From: Ian Stocks [REDACTED] **On Behalf Of** FRS Water and Access
Sent: 17 November 2021 07:58
To: Planning.Responses <Planning.Responses@arun.gov.uk>
Subject: Planning consultation - AL/121/21/PL Rear of Green Gables Northfields Lane Westergate PO20 3UH

Having viewed the details for Planning application no. AL/121/21/PL for the construction of 1 No. new dwelling using the existing access, evidence is required to show that all points inside the dwelling are within 45 metres of a fire appliance. This is a requirement of Approved Document – B (AD-B) Volume 1 2019 edition: B5 section 13.

- 001** Site Overview
- 002** Fire Tender and Car Parking Vehicle Swept Path Analysis

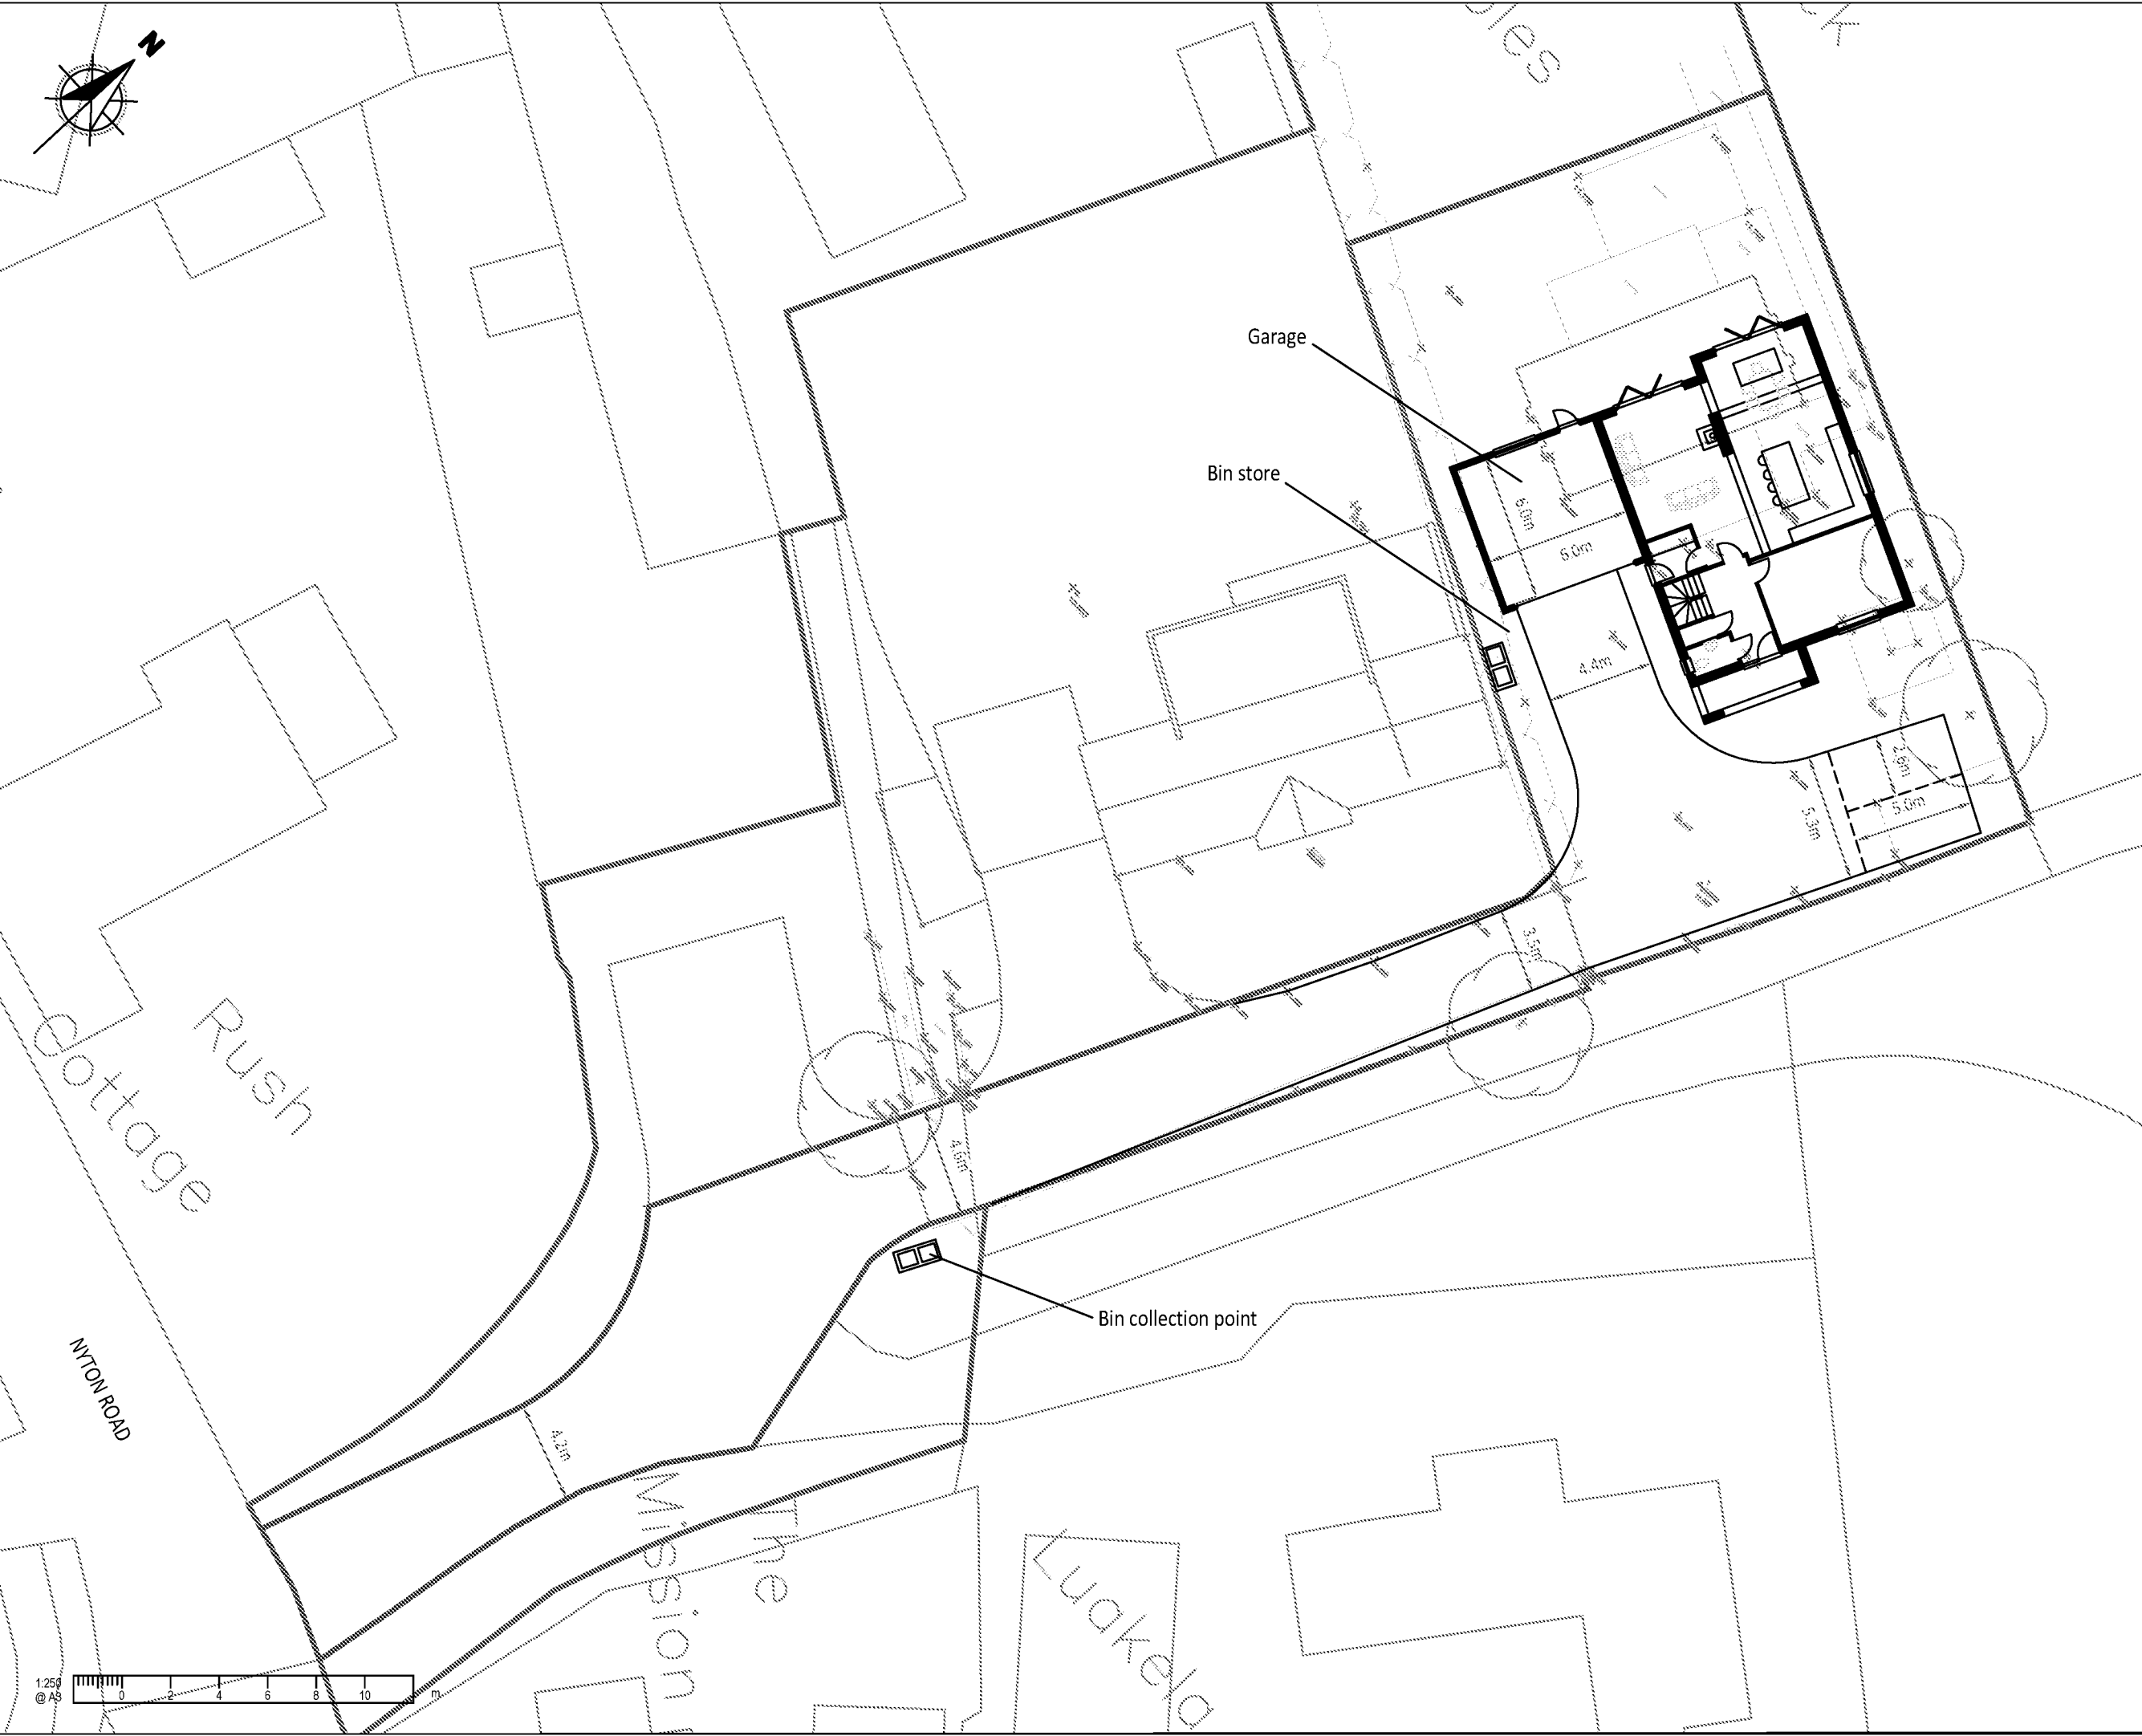
Any areas not within the requirements of AD-B volume 1 section 13 will need to be mitigated by the installation of domestic sprinkler or water mist systems complying with BS9251 or BS8458 standards.
